LSC TRANSPORTATION CONSULTANTS, INC.
545 East Pikes Peak Avenue, Suite 210
Colorado Springs, CO 80903
(719) 633-2868
FAX (719) 633-5430
E-mail: lsc@lsctrans.com
Website: <http://www.lsctrans.com>

MEMORANDUM

SUBJECT: Lorson Ranch East
(PUDSP-16-003) Review 2
Response to Comments Memorandum
LSC #164360

Following are the LSC Transportation Consultants, Inc. responses to the August 15, 2017 El Paso County Planning and Community Department comments letter regarding the July 12, 2017 Updated Traffic Impact and Access Analysis by LSC.

# Future Multi-Lane Design Exhibits

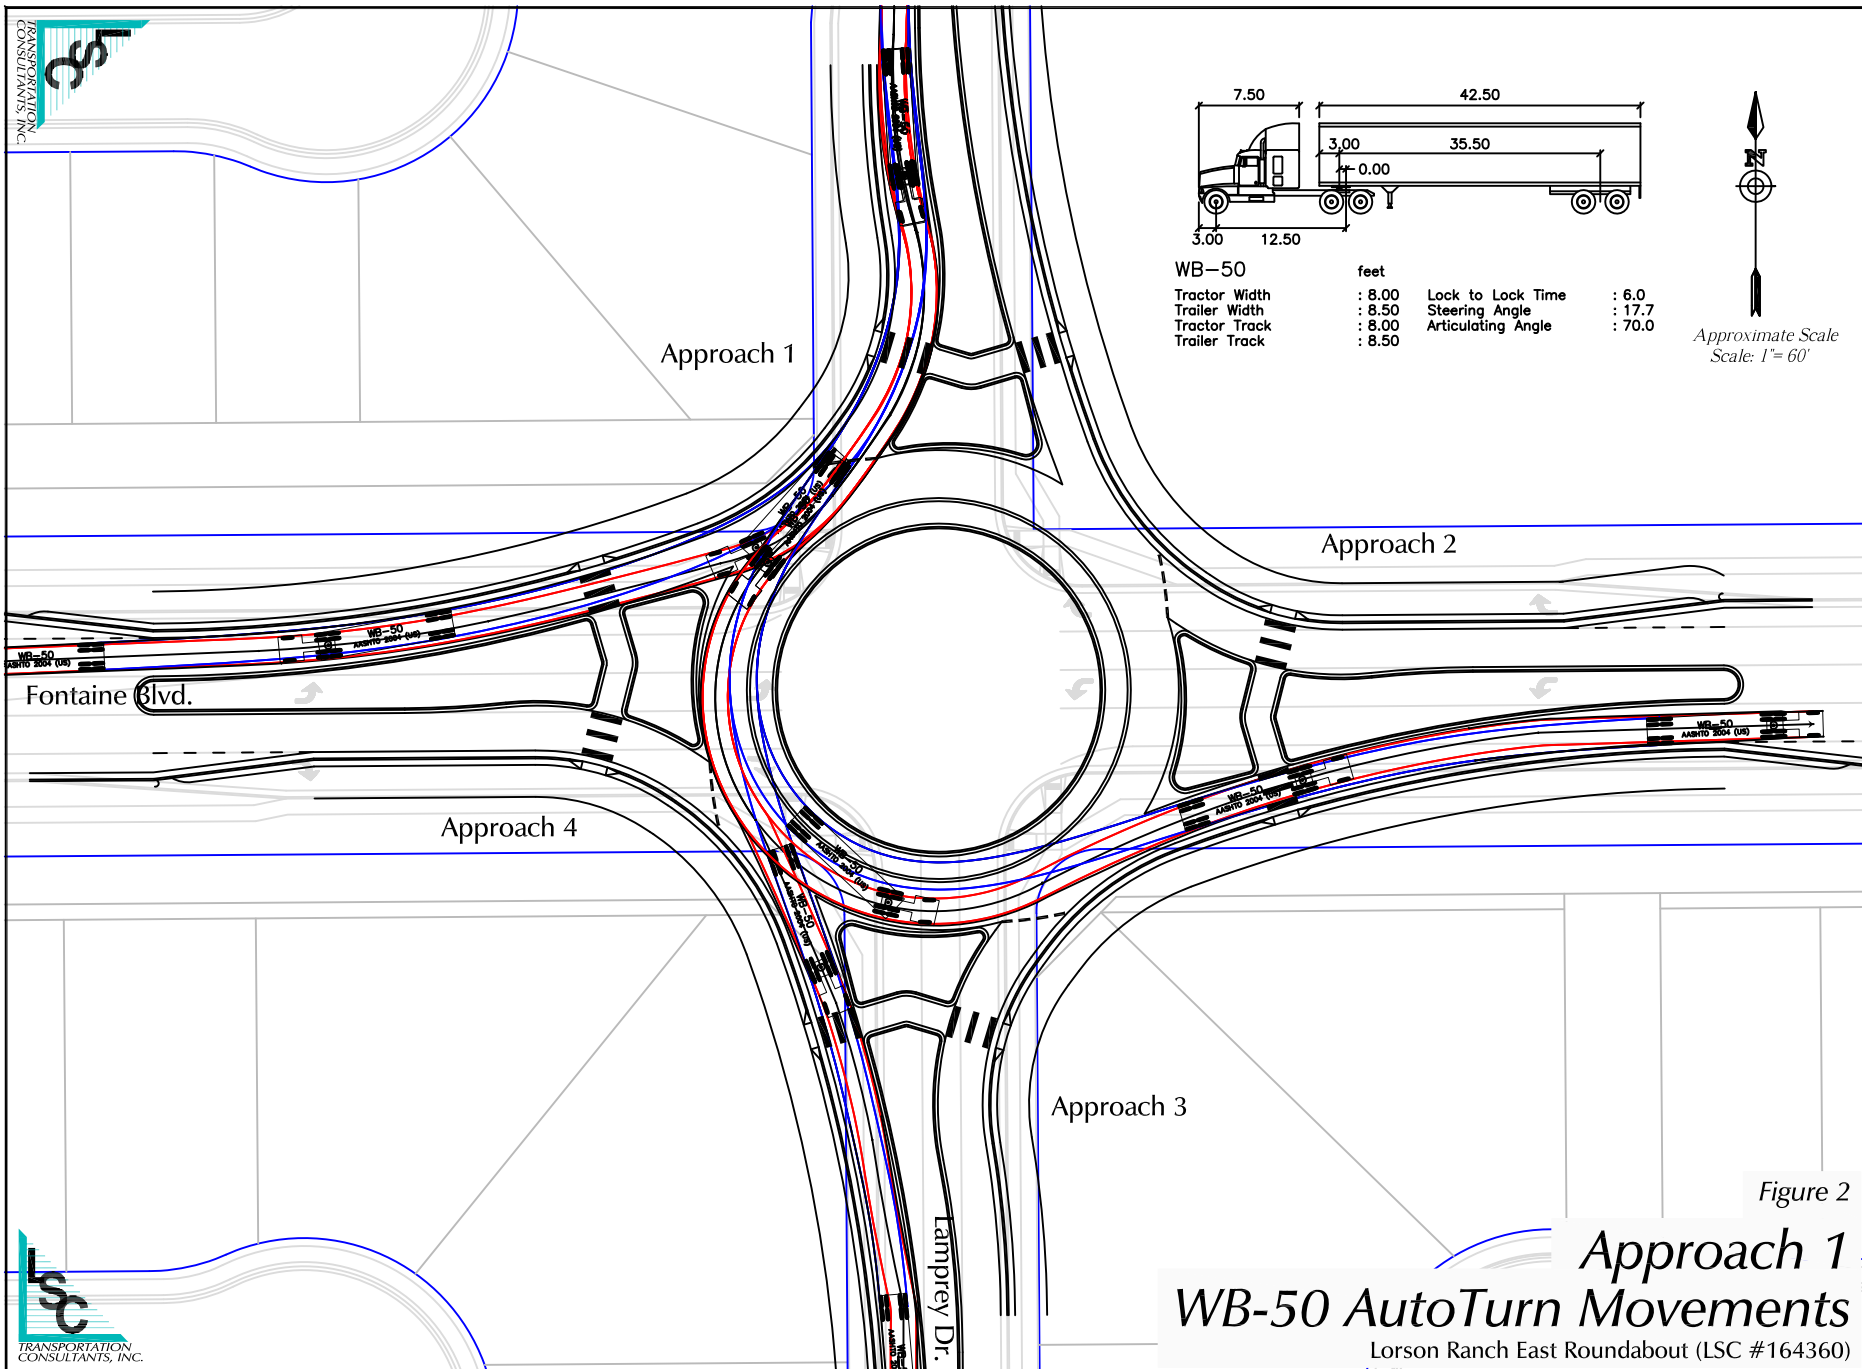
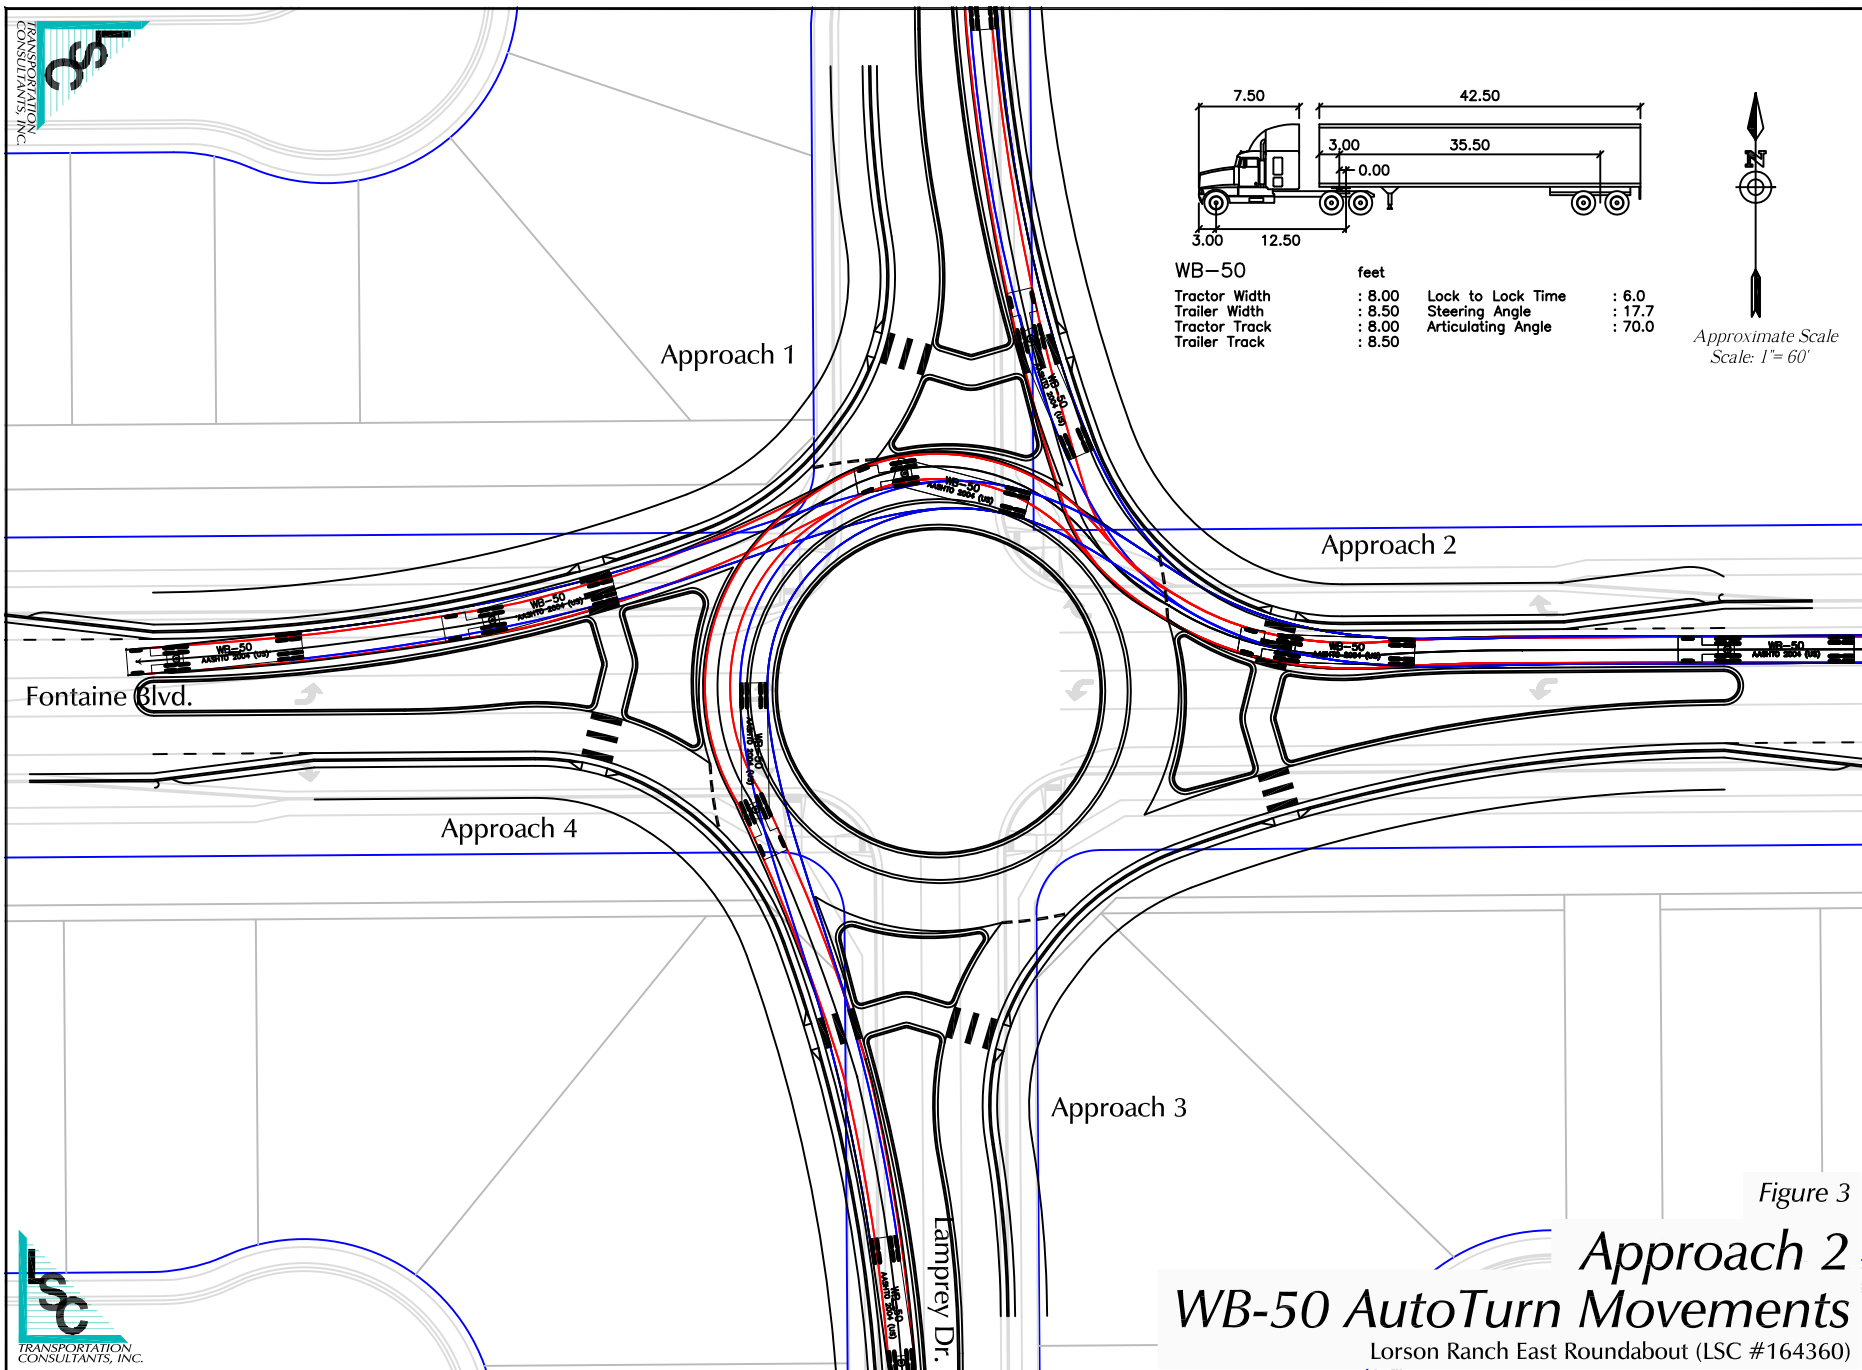
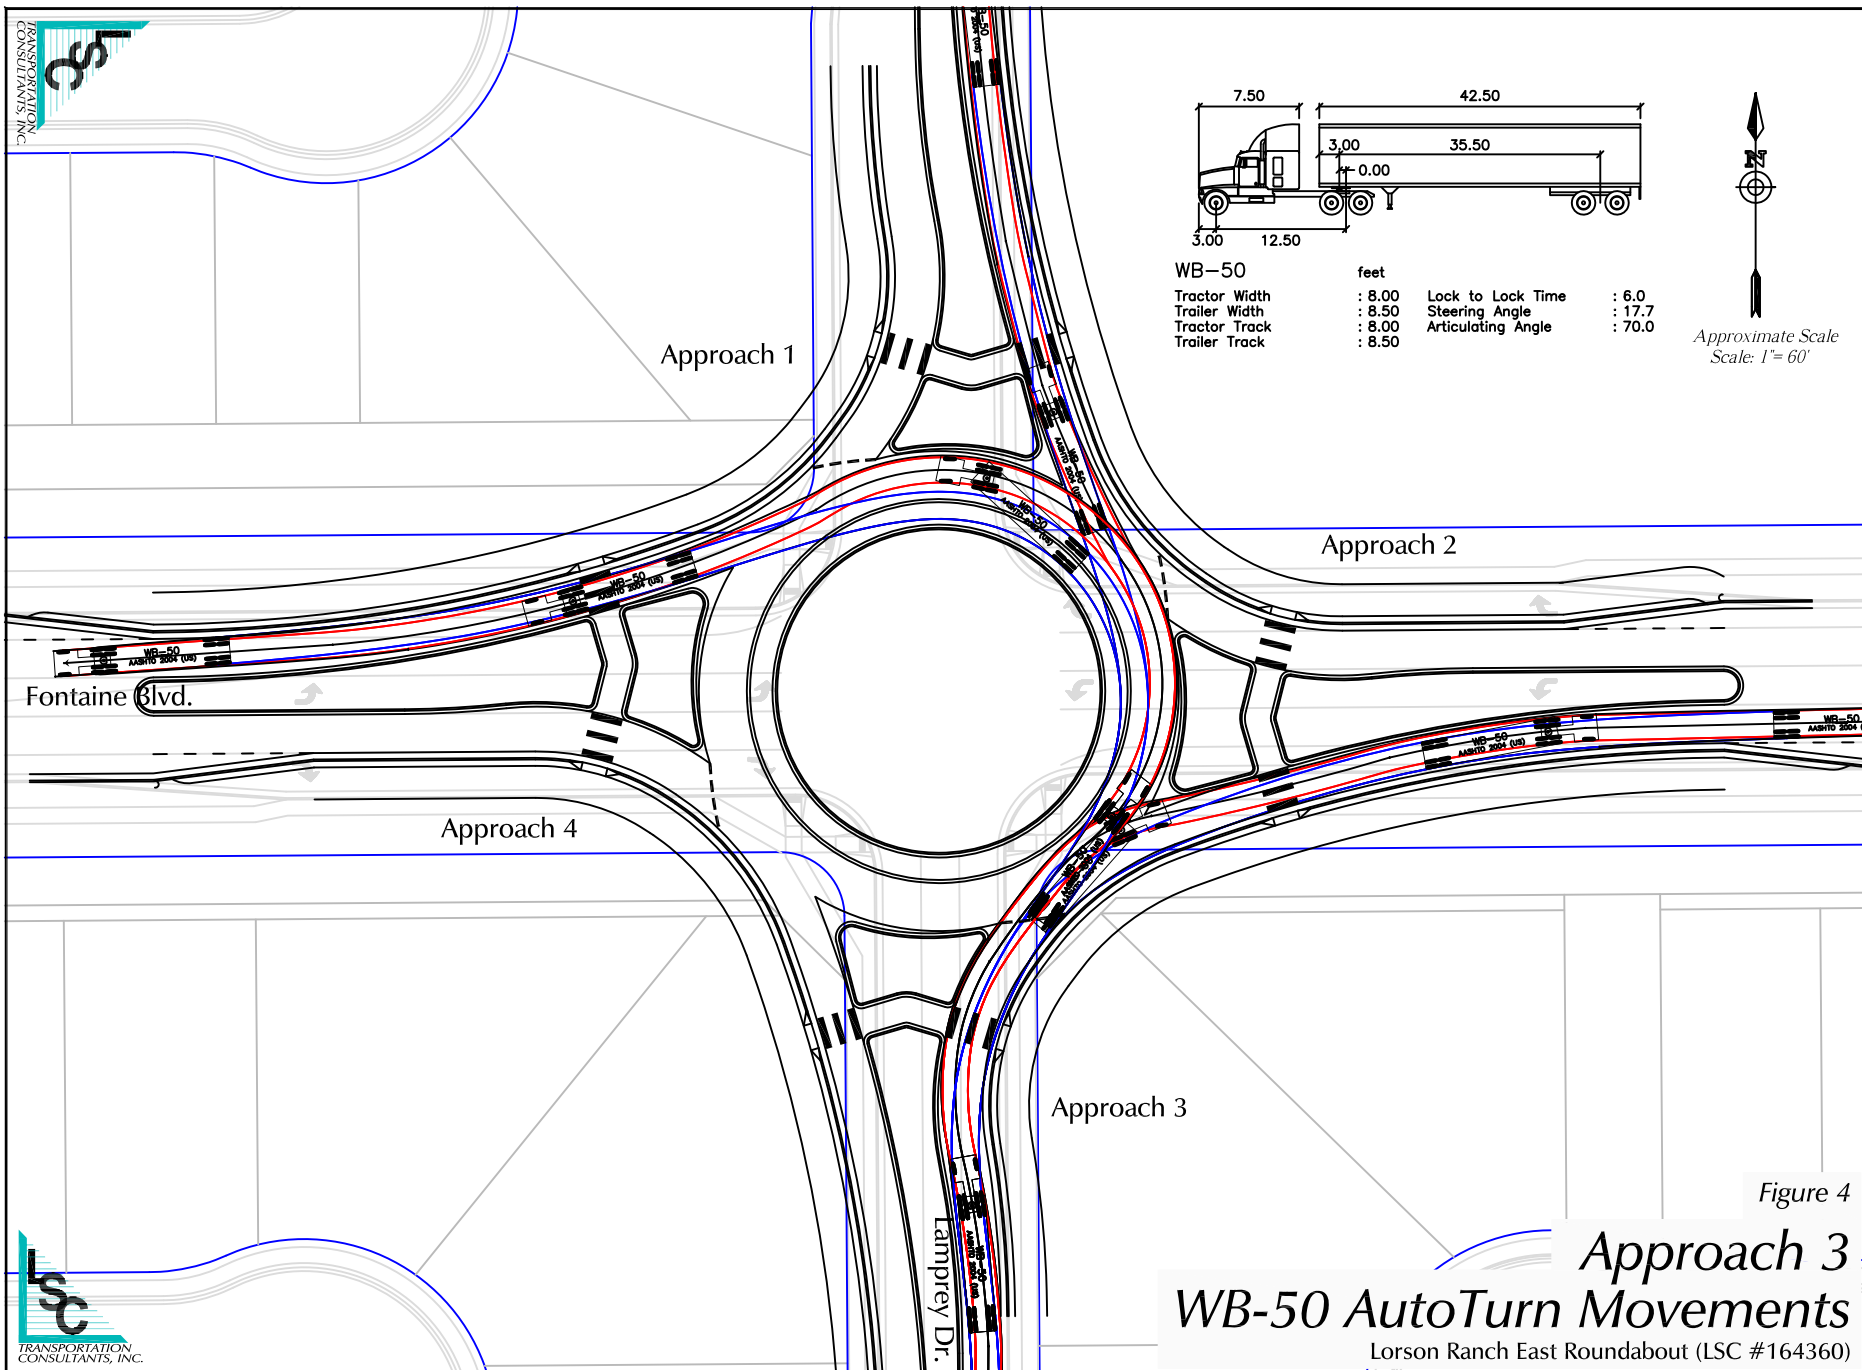
8. *Regarding the e-mailed comments dated March 17, 2017:*
*a. **It needs to be clearly documented that the roundabout is the proposed intersection at Lamprey/Fontaine. If the roundabout is the chosen option, could it not be designed to be expandable to 2-lanes when necessary along with widening of Fontaine Blvd.?***

LSC Response: The updated TIS clarifies this and clearly presents the roundabout as the proposed solution. The report also includes a roundabout design report and exhibits with the design of a future two-lane roundabout.
